STATUTORY PLANNING CONSULTATION RESPONSE

Application Number:	3/2026/0573
Proposal:	Approval of details reserved by conditions 17 (Surface Water Drainage Strategy) and 18 (Construction Surface Water Management Plan) of appeal decision 6001560 (planning application reference 3/2025/0653).
Location:	Higher College Farm Lower Road Longridge PR3 2YY

CEMP – Site Management Plan

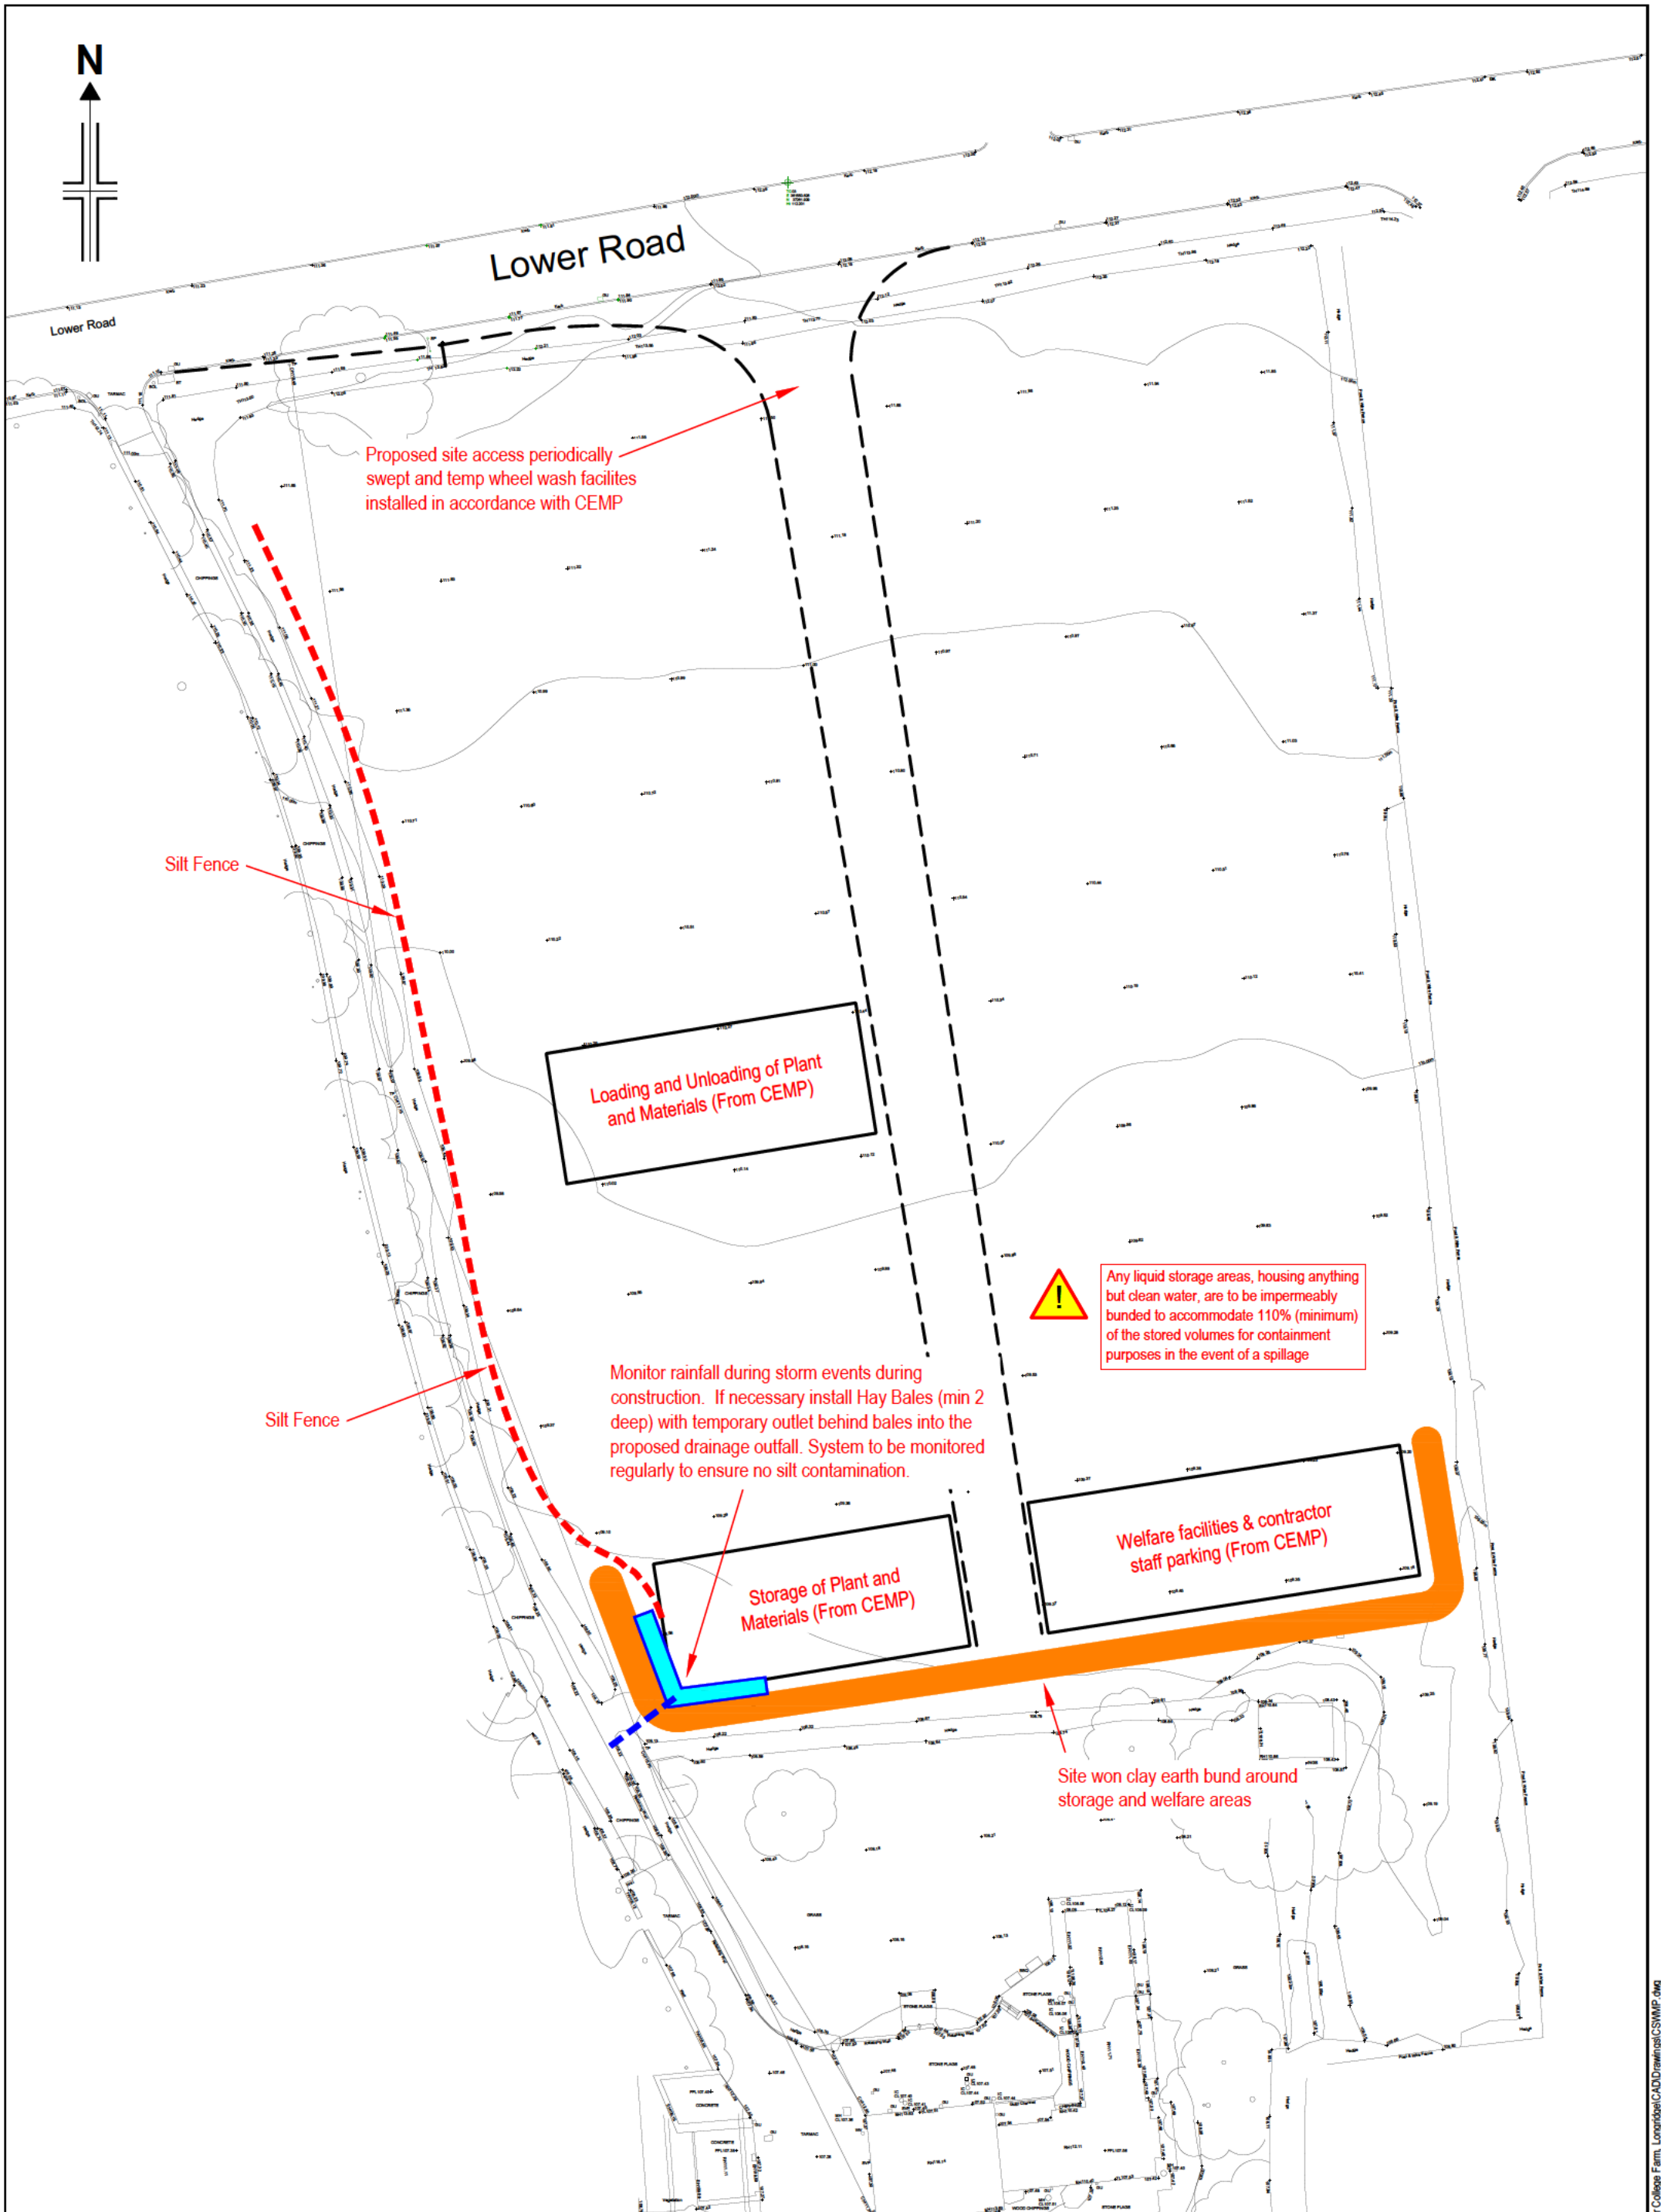
- The applicant has failed to provide evidence to demonstrate an appropriate location of where surface water will be collected and rained onsite and how the applicant intends to control the discharge of this surface water from the development during the construction phase prior to the drainage being implemented in full, and so it does not exceed the equivalent greenfield runoff rate.

For the avoidance of doubt, the applicant has stated that the bunds will temporarily store surface water runoff, however, the applicant has also located the welfare units and storage of plant and materials in this same location.
